# CITY OF ALBUQUERQUE

PLANNING DEPARTMENT – Development Review Services

**RE: Aviation Center of Excellence - ACE (M16D024N)**  
**Conceptual Drainage Plan**  
**Engineer Stamp Date: 9-10-15**

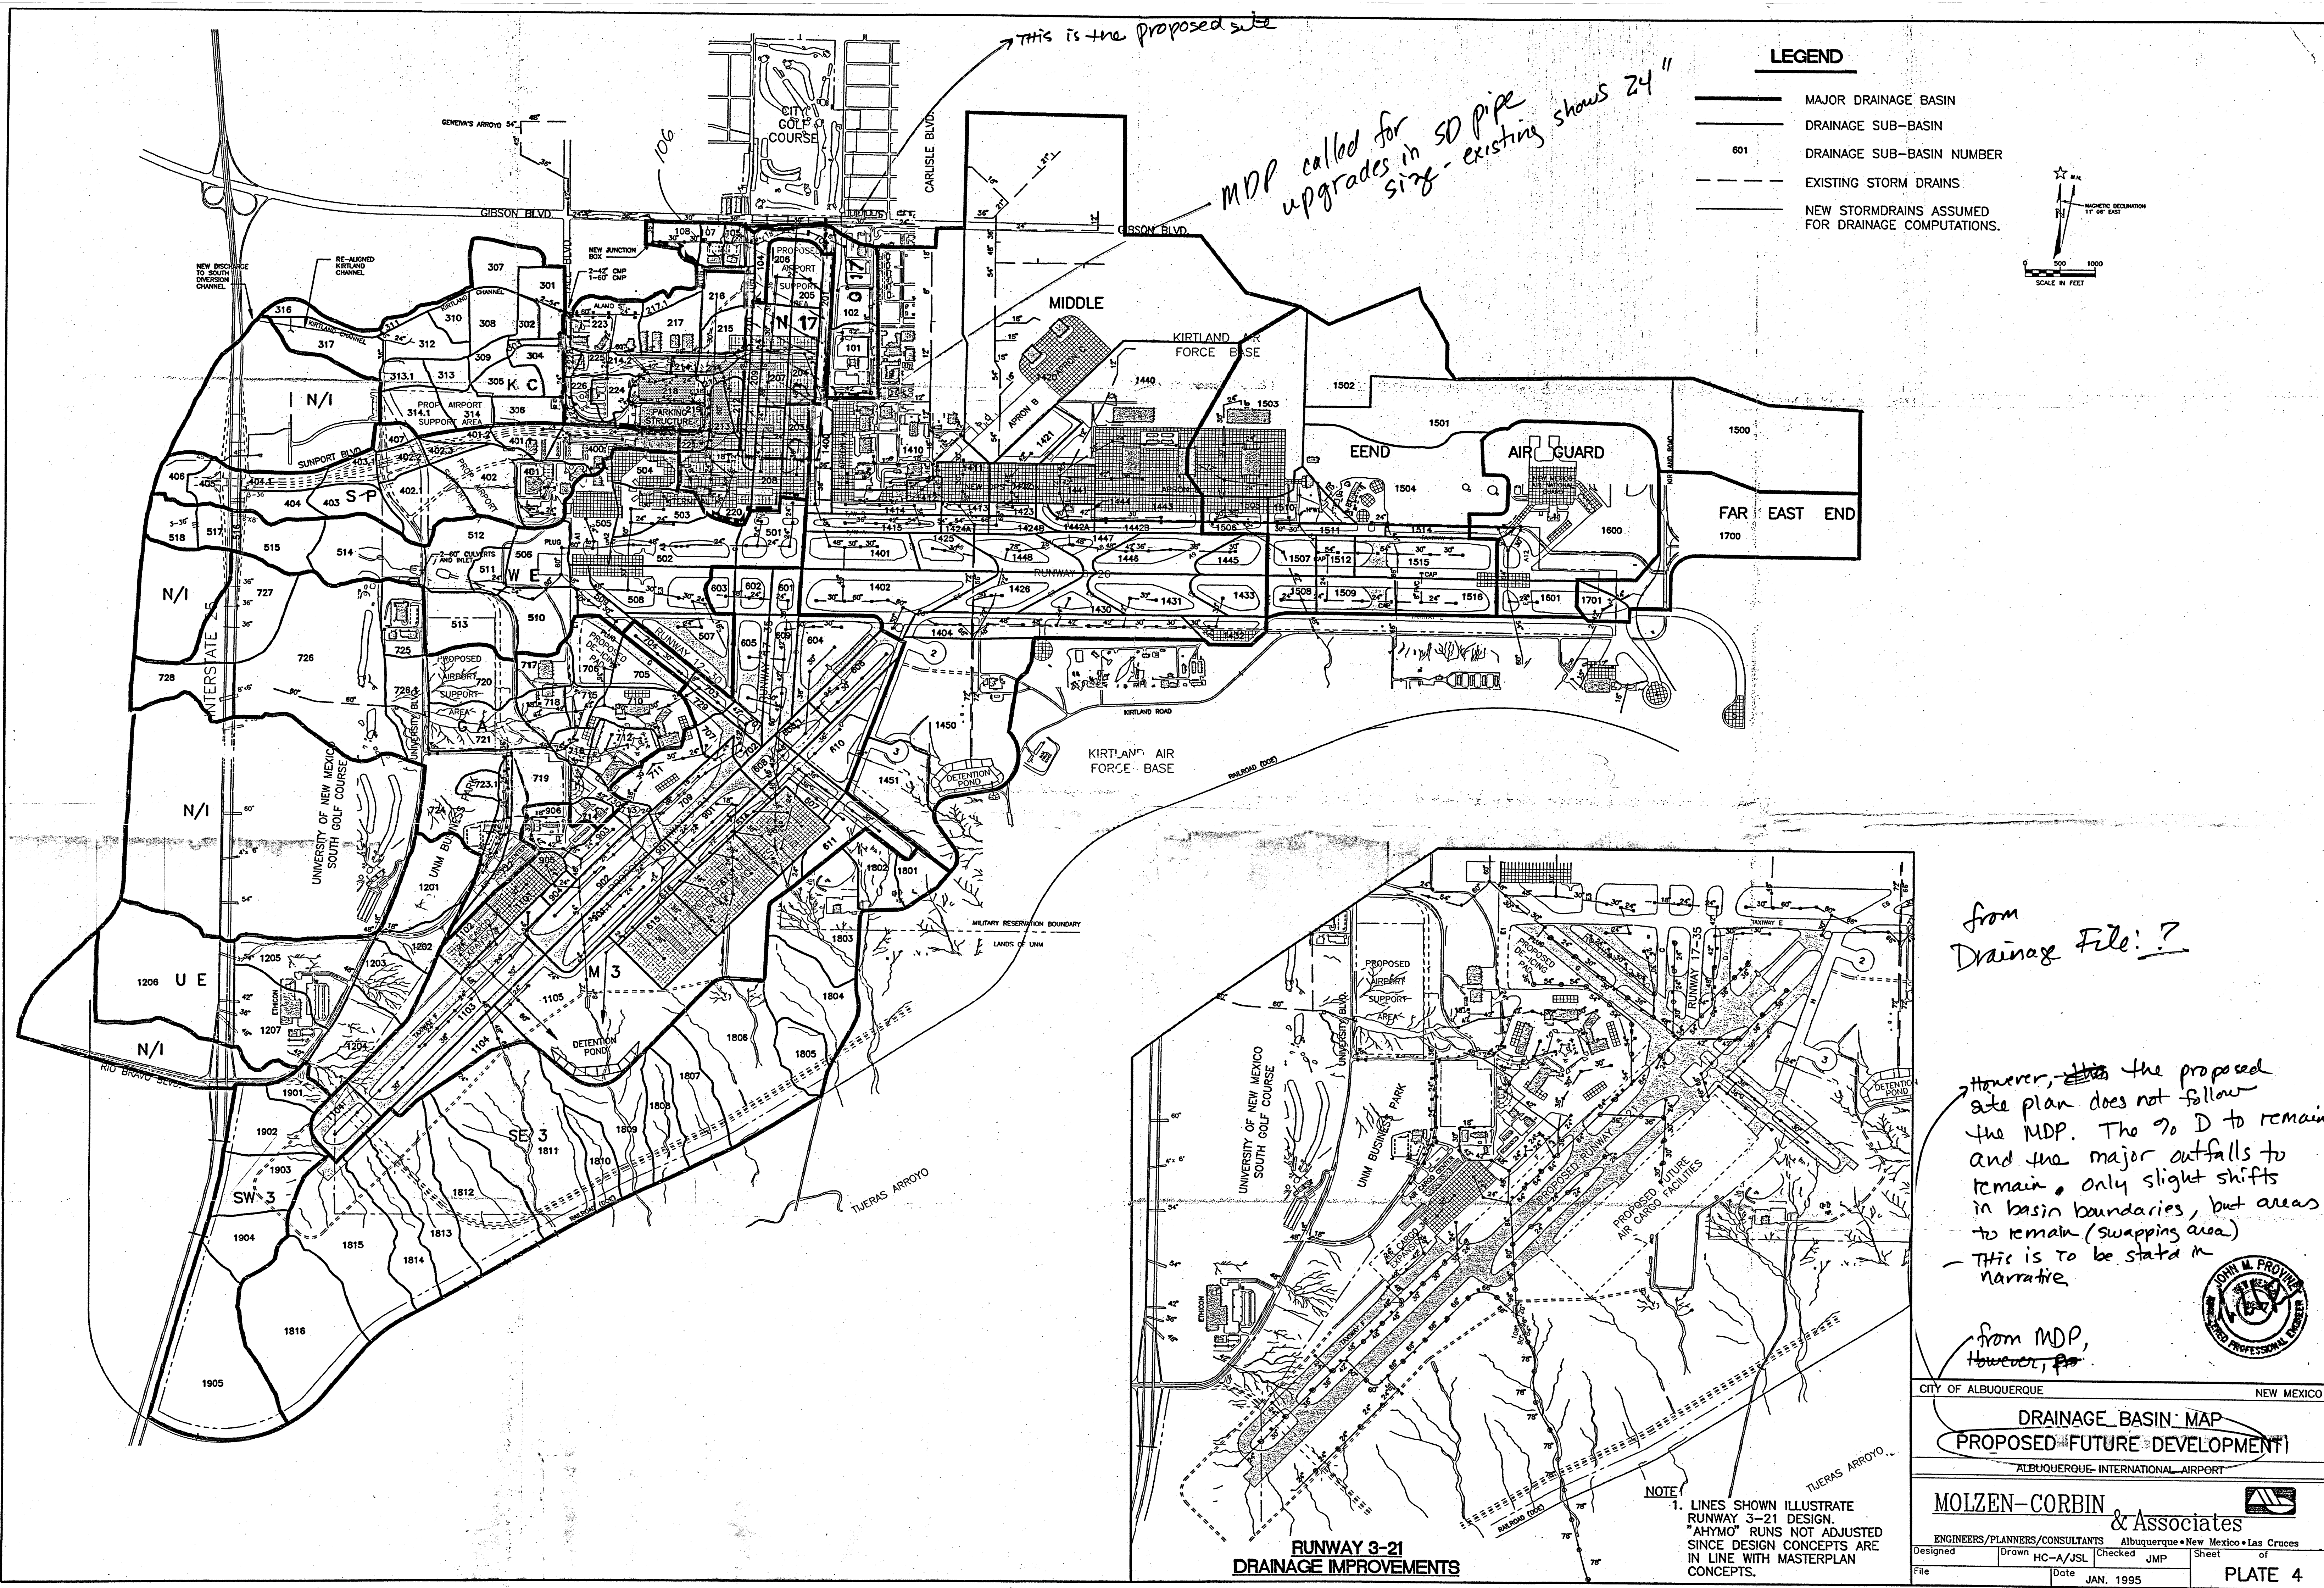
1. Because this project is owned by the City of Albuquerque Aviation Department, standard process procedures may not apply. In this case, this plan will serve as the Master Drainage Plan for the future development of the Proposed Leased Lots. Rename the Title sheet as DRAINAGE MASTER PLAN.

4. Show and label the actual Legal Property Boundary.
5. Reference the Drainage File of the older Master Drainage Plan, AIA DMP – M16D024
6. In Existing Conditions paragraph, the acreage should match that show on the Site Plan. The Site Plan says 70 acres and this plan says 116 Acres.

7. Compare the Total Flow from Table 1, 498 cfs, to the Total allowed from the AIA DMP for the same sub-basins. For the sub-basins that are not fully within the new Major Basin, use some percentage of the sub-basin. For ex. Use 80% of Basin 205, or whatever is the appropriate value.

8. Determine what is the status of the 24" Storm Drain and inlet that extends to the eastern boundary as well as the 48" upgraded Strom Drain shown on the "Proposed Future Development" plan.

9. Show the modified basin boundaries and Label as G17 and N17. The plan will probably need to be scaled down slightly so that the most southern boundary of N17 can be shown. It needs to be clear that the southeastern portion of the N17 basin is to discharge to the existing

inlets at the Aircraft Apron. The need not be shown. Show the western portion of basins G17 and N17 to the extent possible.

10. According to the MDP, Basin 209 is supposed to drain to 42" SD "Between T/W and Access Road". Where is this on the new MDP? Where does the western edge of Basin 209 lie relative to the limits of the new MDP? Is it Girard?
11. Does some portion of Basin 220 lie within this plan? Is it still following the planned outfall to the 36" SD? Where is this outfall located?
12. Based on the above comments in 9,10, and 11, it may be more useful to provide a Basin Boundary map, showing the location of the sub-basins and Major basins from the AIA DMP overlayed over this new DMP, showing the new Major basin boundaries (N17 and G17).
13. When resubmitting, mark off Master Drainage Plan on the DTIS sheet as the Type of Submittal.
